Subject: Highways England Response (HE ref. 89793 #11944) re. BN/142/20/OUT - Land South of Barnham Station

For attention of:	Raymond Cole
Site:	Land south of Barnham Station, Barnham
Proposal:	Outline planning application with all matters reserved, other than principal means of access, for up to 200 No. dwellings, with access taken from Marshall Close, associated infrastructure & landscaping & demolition of existing buildings. This application is a Departure from the Development Plan, may affect the setting of listed buildings, may affect the Church Lane, Barnham Conservation Area & affects a Public Right of Way.
Your Reference:	BN/142/20/OUT

TO:	Arun District Council FAO: Raymond Cole
FROM:	Stephen Gee WSCC - Highways Authority
DATE:	16 December 2020
LOCATION:	Land south of Barnham Station Barnham
SUBJECT:	BN/142/20/OUT Outline planning application with all matters reserved, other than principal means of access, for up to 200 No. dwellings, with access taken from Marshall Close, associated infrastructure & landscaping & demolition of existing buildings. This application is a Departure from the Development Plan, may affect the setting of listed buildings, may affect the Church L

FIGURE 49. Plan showing proposed highway improvements to Marshall Close (i-transport)

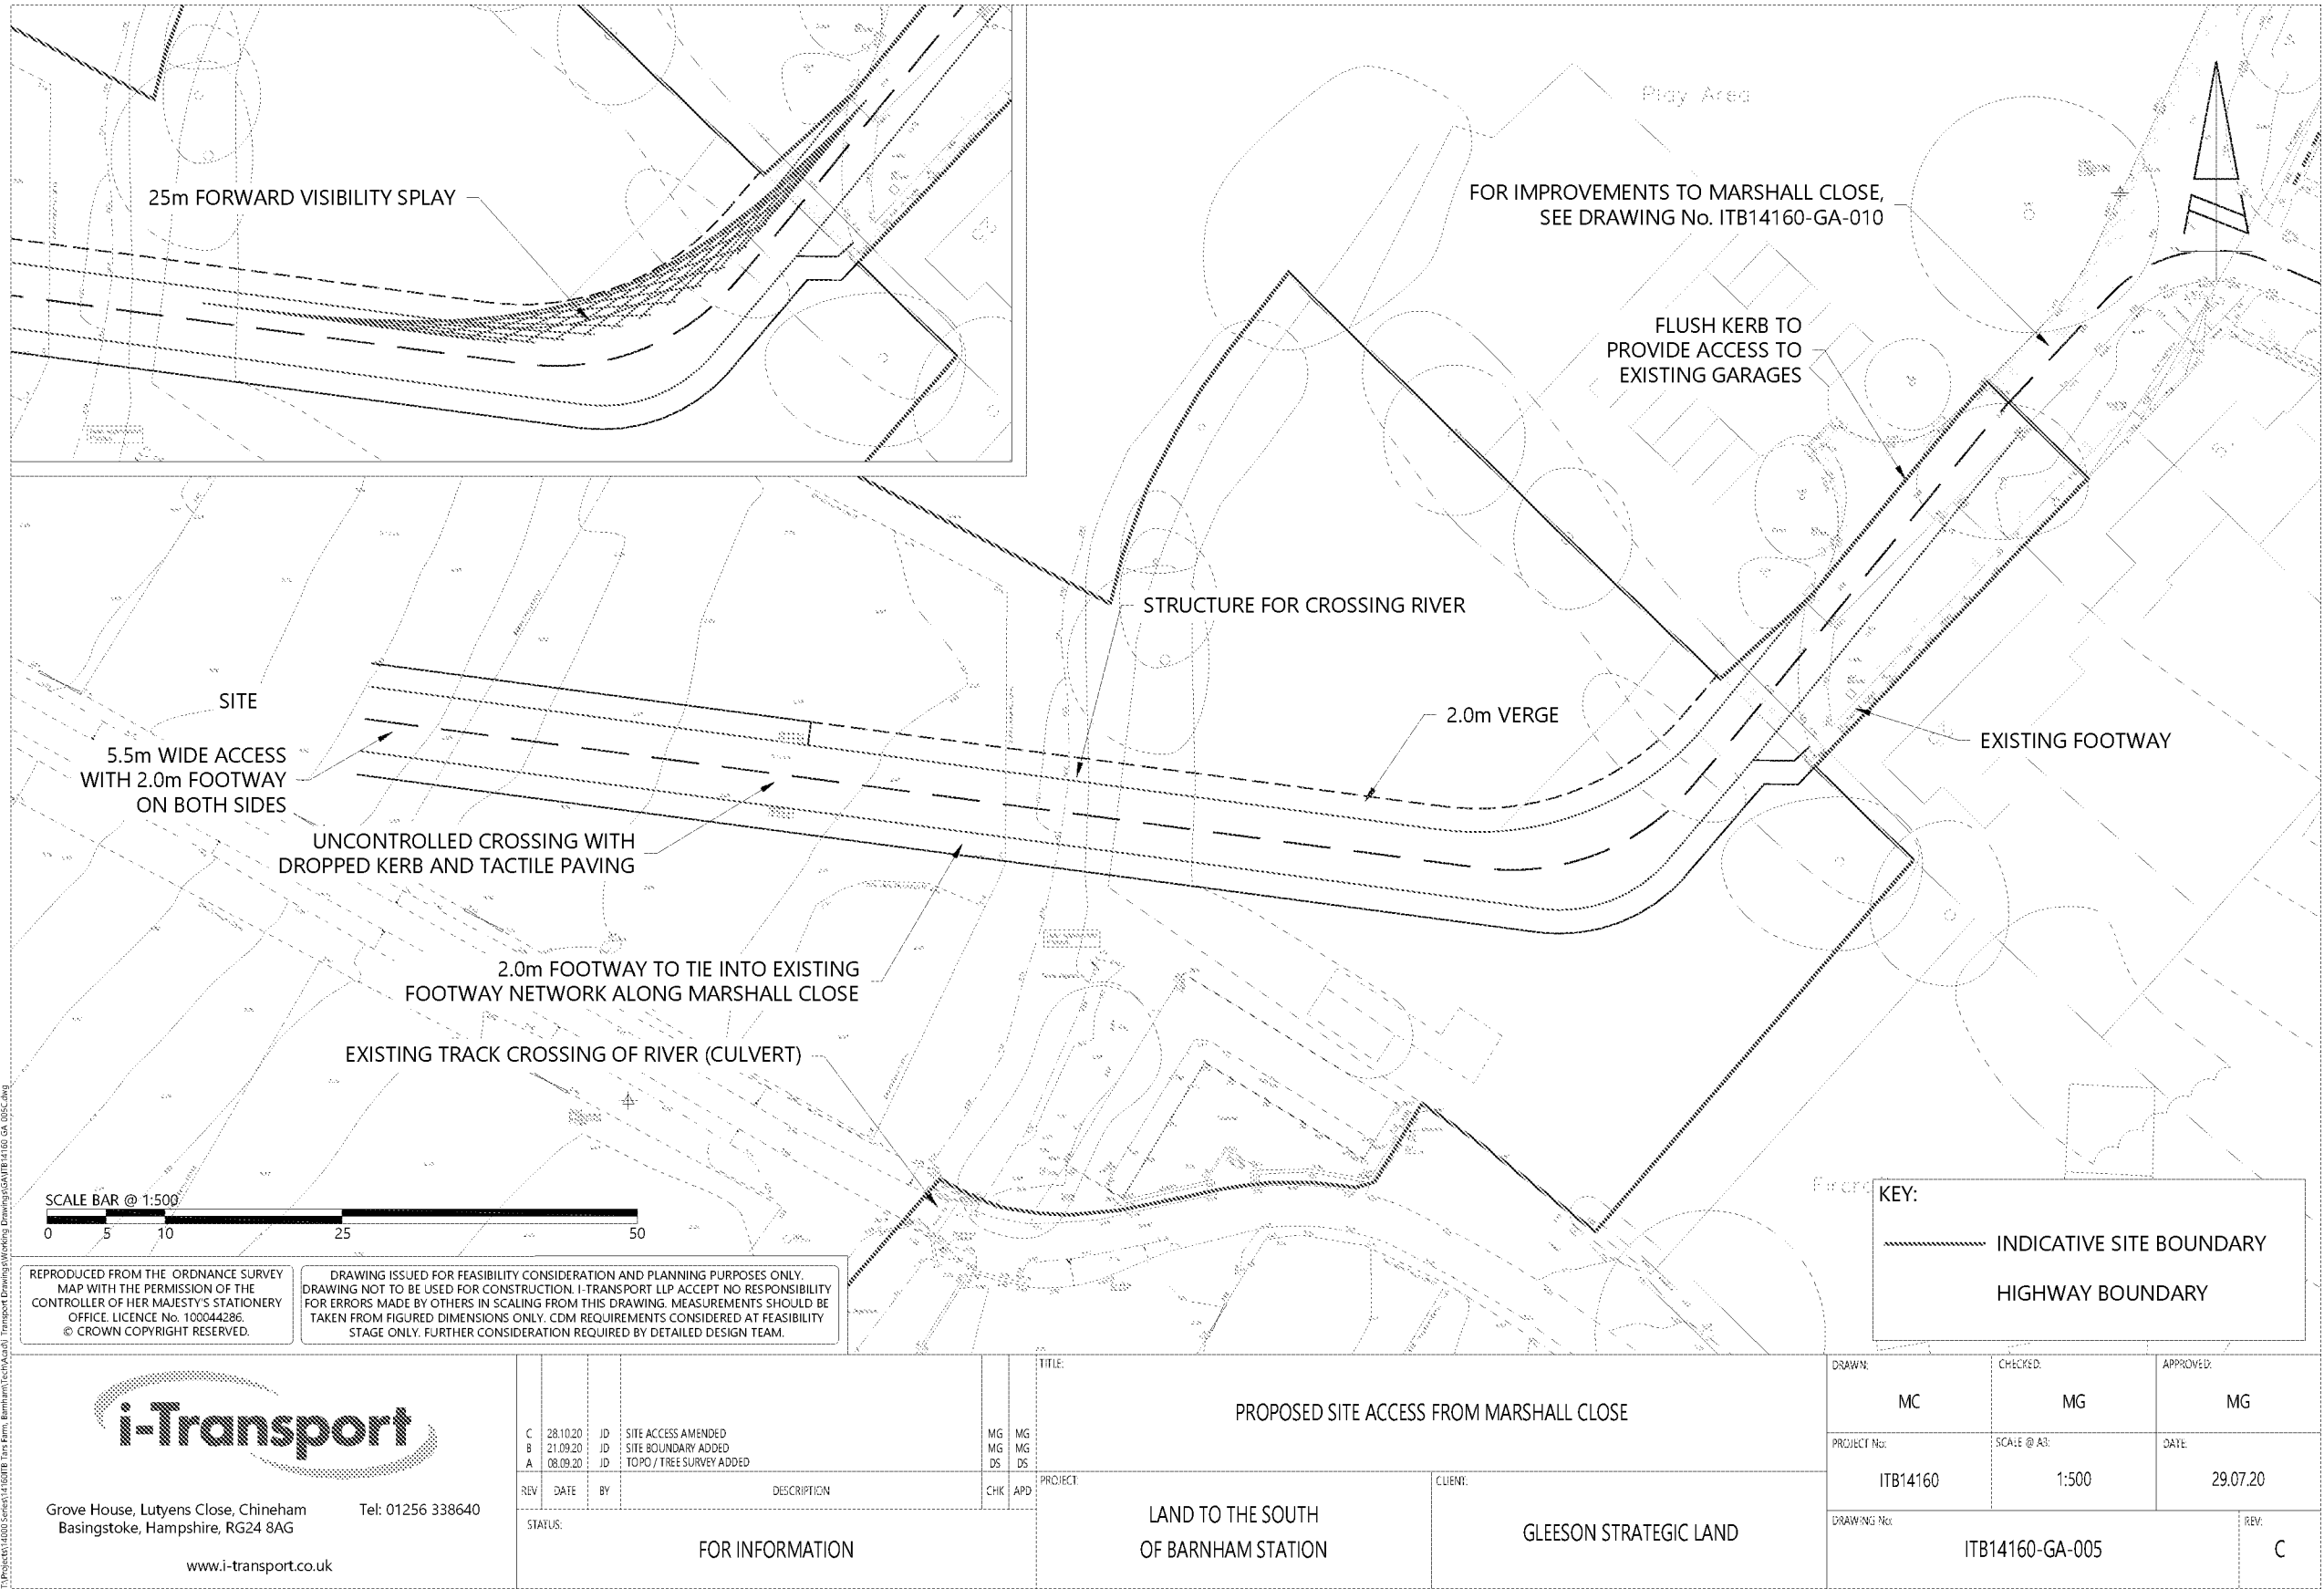
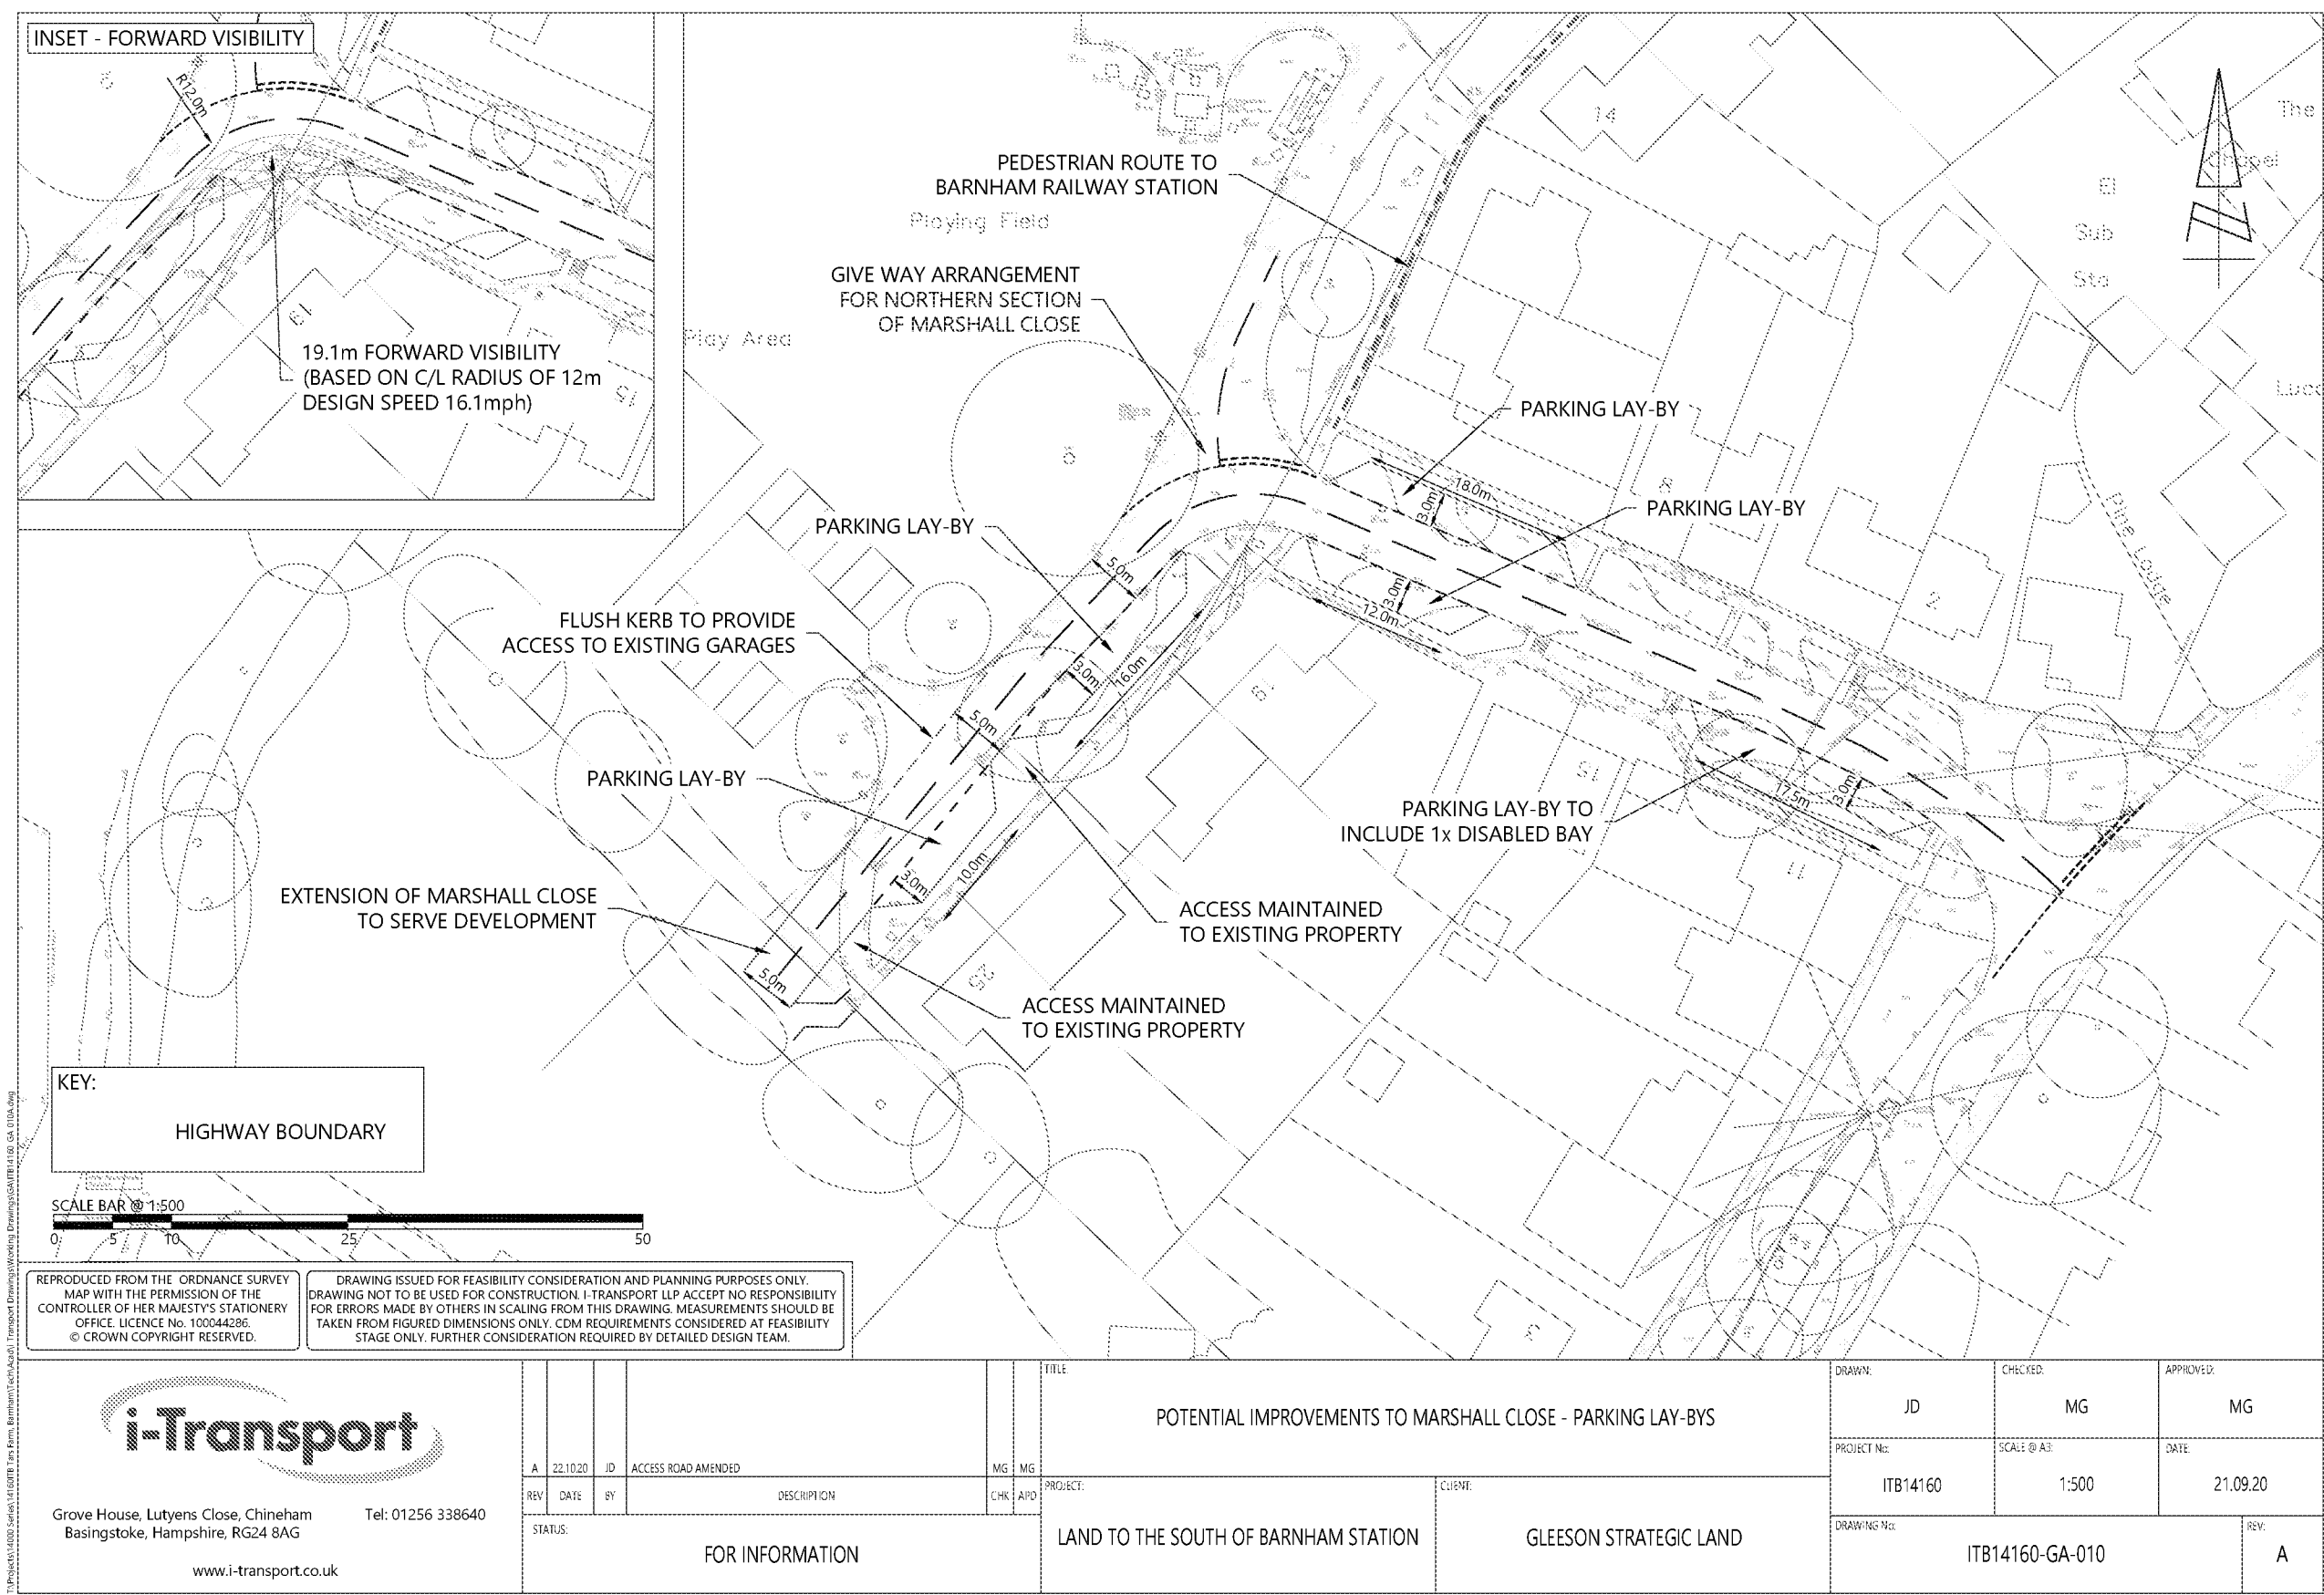
The site is to be accessed via an extension of Marshall Close. The access road is to measure 5.5m with a 2m wide pedestrian route into the site. Once within site 2m footways would be provided on both sides.

Marshall Close is currently subject to on street parking and as such off-carriageway laybys are proposed which would accommodate 12-15 vehicles. The remaining width of 5m would be sufficient for a large vehicle to pass a car.

Swept path analysis as been provided and shows 2 cars can pass along Marshall Close, whilst a refuge vehicle would not be able to pass a car around the bend this would be an infrequent movement and forward visibility of 19.1m is achievable commensurate to a 16mph design speed.

Following consultation with the WSCC fire and rescue access manager no emergency access is required provided a 3.7m clear width can be provided along Marshall Close to which the parking bays would allow a fire tender to pass.

No stage 1 RSA has been provided for the proposals and should be done so.

The applicant should identify where tactile paving/drop kerbs are required between the site and Yapton Road.
